Householder Application for Planning Permission for works or extension to a dwelling. Town and Country Planning Act 1990

ADDITIONAL WINDOWS + ROOFLIGHTS TO BATH (CONVERSION).

PRE- APPLICATION ADVICE, LANE ENDS BARN, BALDERSTONE

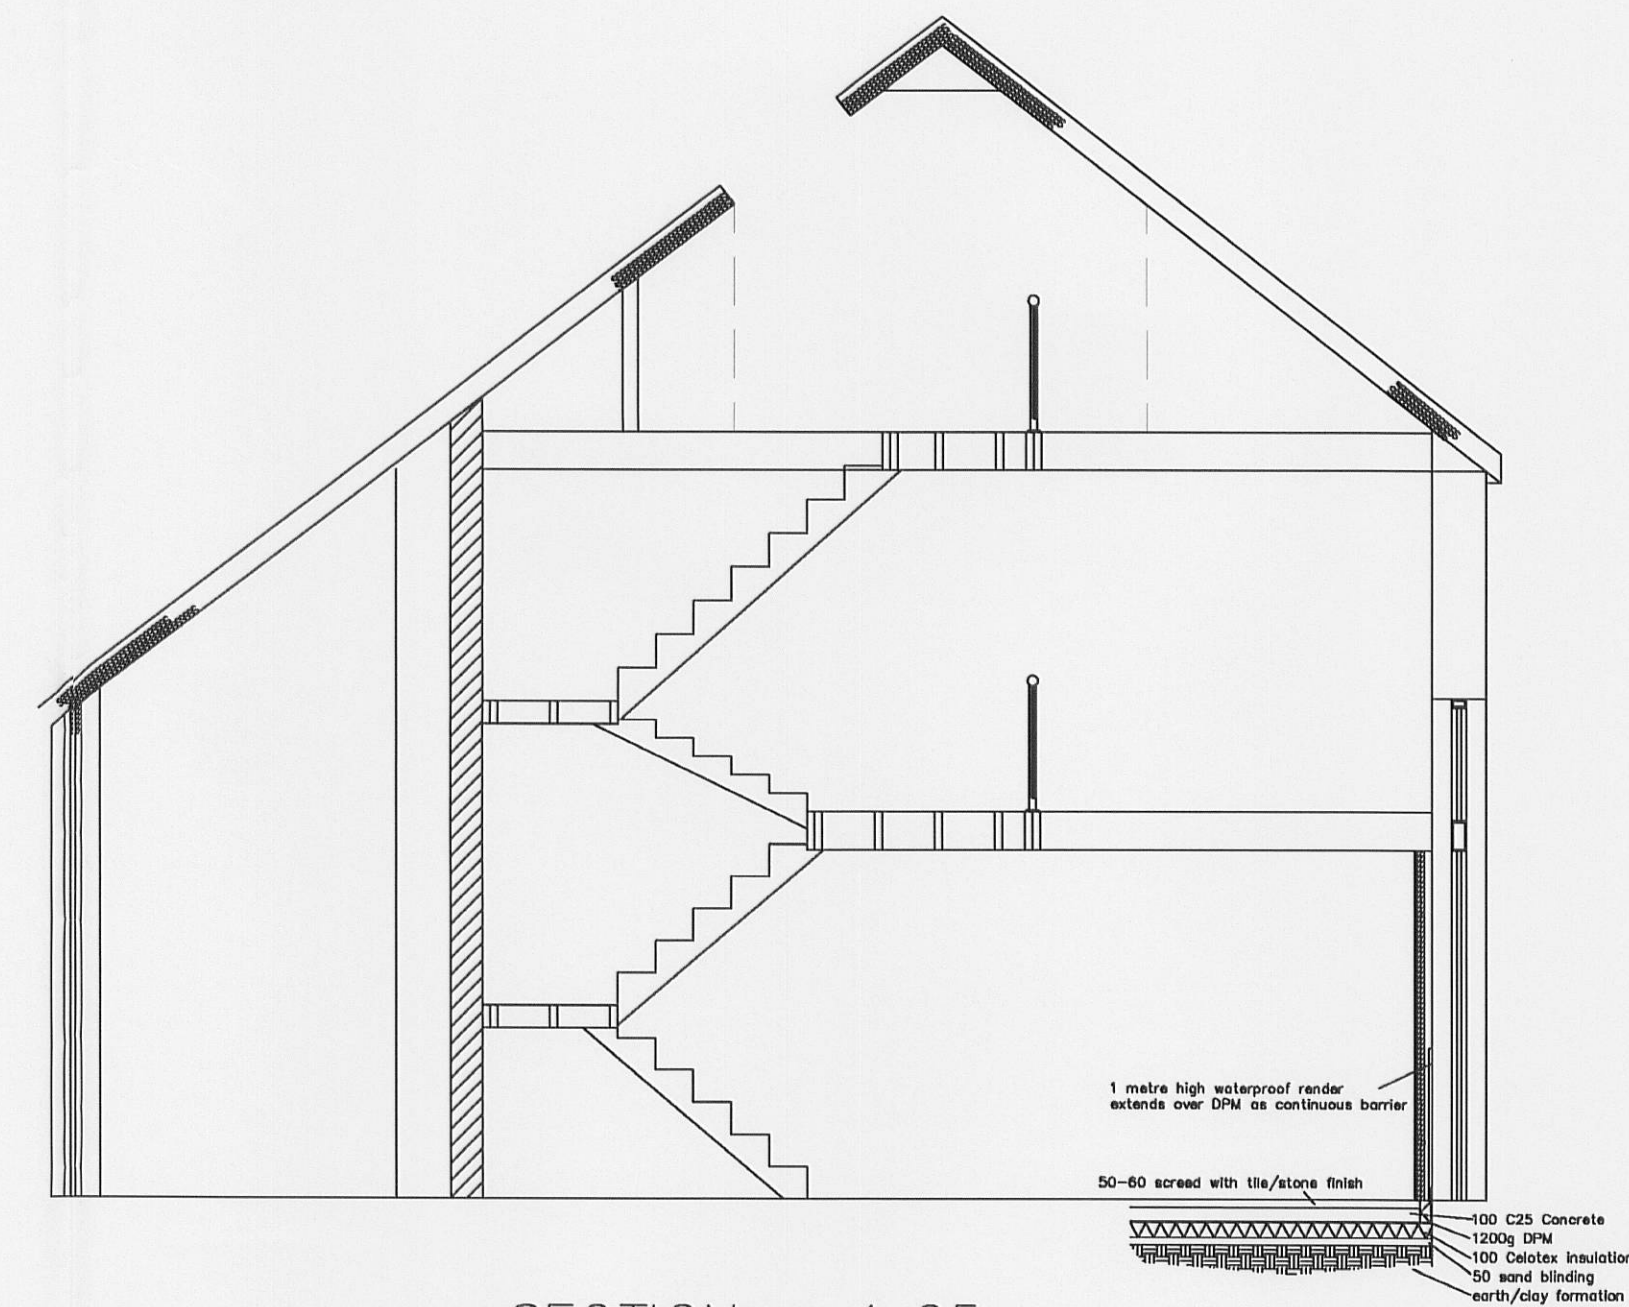
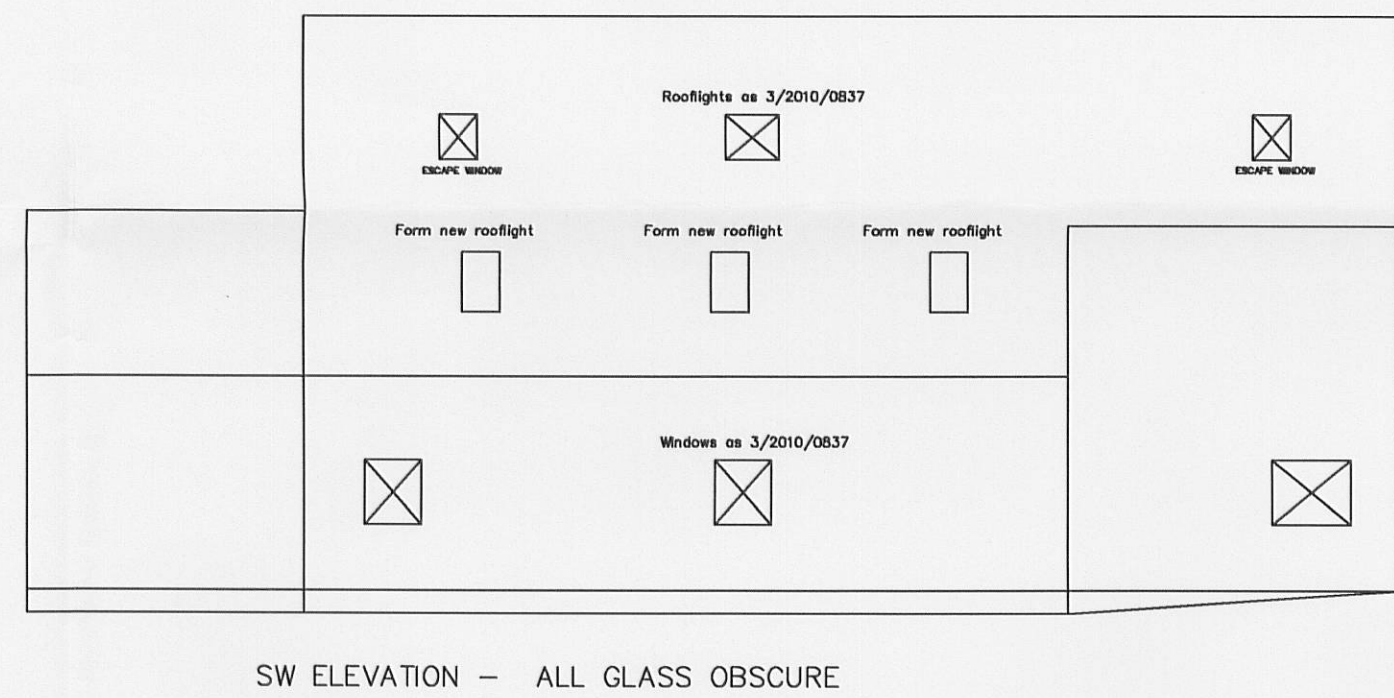
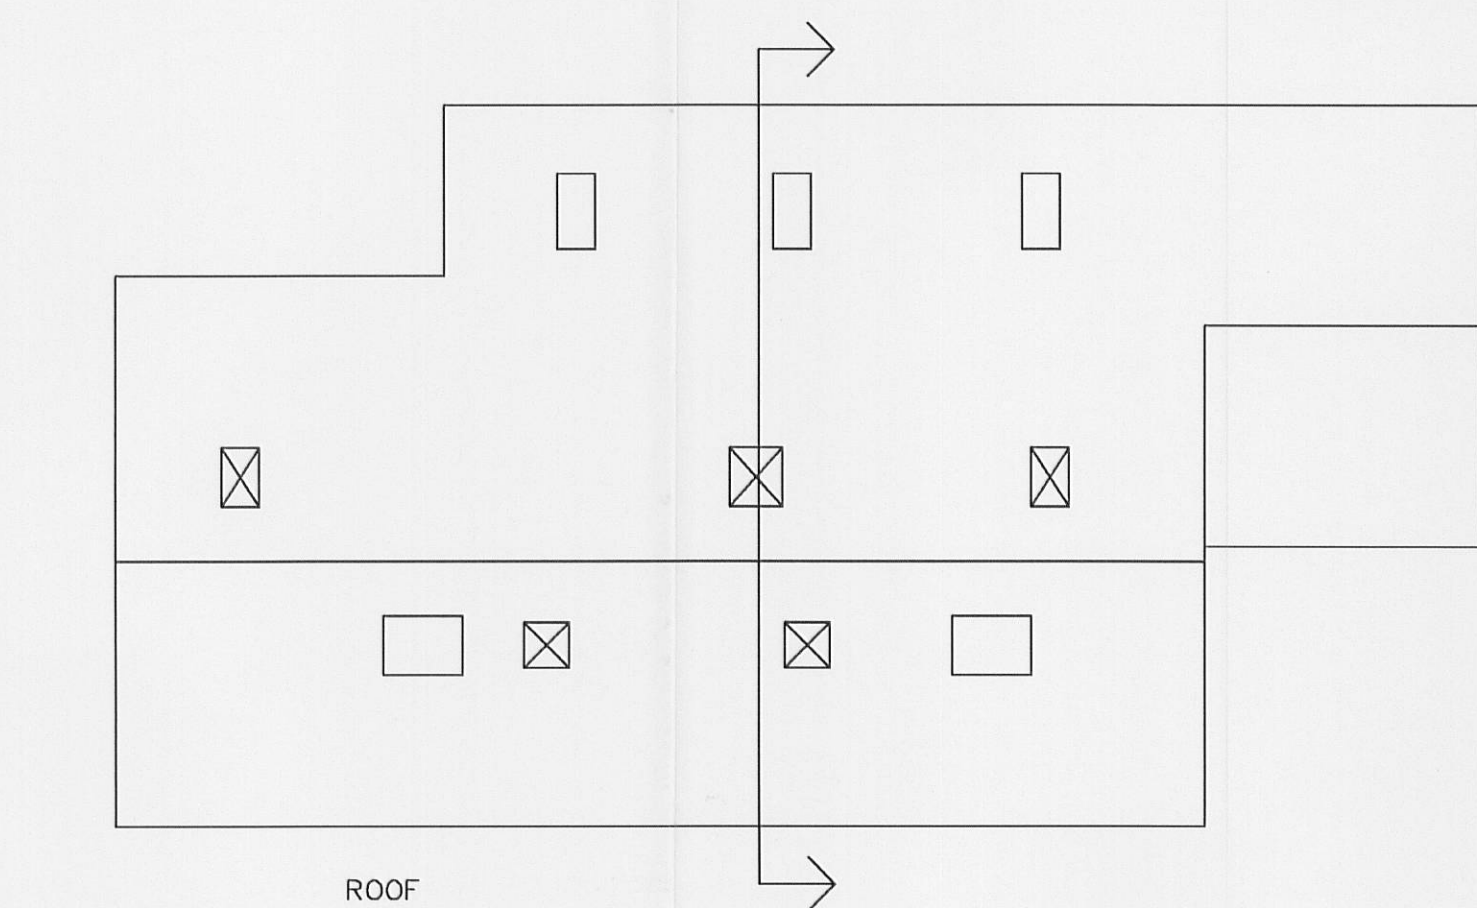
South East- Perhaps one additional opening would be allowed on this elevation, but this would be at the expense of one of the consented new openings on an alternative elevation, perhaps the one that you are proposing to delete on the north west.

North West- Fine, deleted window could be relocated elsewhere on the building

North East- The roof terrace is contrary to policy, as discussed above. An additional window could be permissible on this elevation, but regular dwelling- type orientation as shown on the two windows either side of the barn door, would be resisted, as this would give the building an overly residential external character. The larger window at first floor level, and the replacement of the door with a window of similar dimensions immediately below would further impact on the barn's appearance, making the openings look too regular and residential in character. There is potential for a further two rooflights on that elevation, though, as drawn, given the four existing transparent roof panels on the barn.

South West Elevation- The additional rooflights would be resisted, however, some reorientation of the consented openings may be permissible.
